April 30, 2014

RE: Existing Septic System Inspection HTE# 14-5-33468

An attempt was made to evaluate your property for the purpose of issuing an Existing Tank Permit. The evaluation could not be completed for one or more of the following reasons.

**PLOT PLAN**

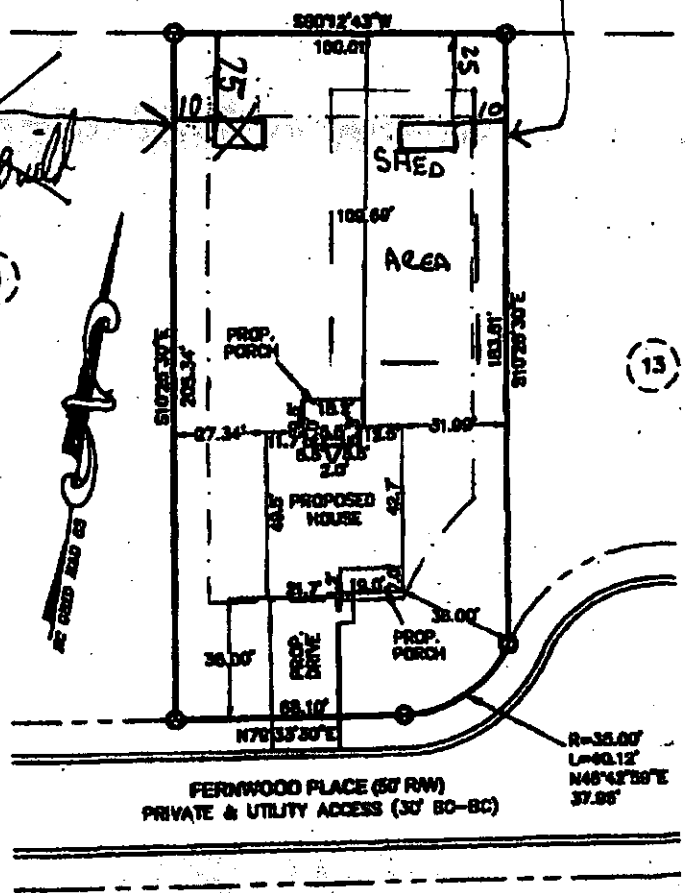
- 1. Uncover outlet lid on septic tank and break seal (**\$25.00 fee incurred**)
- 2. Have system pumped out
- 3. Replace sanitary T
- 4. Other – Shed must be moved out of initial drain field area, see the attached drawing.**
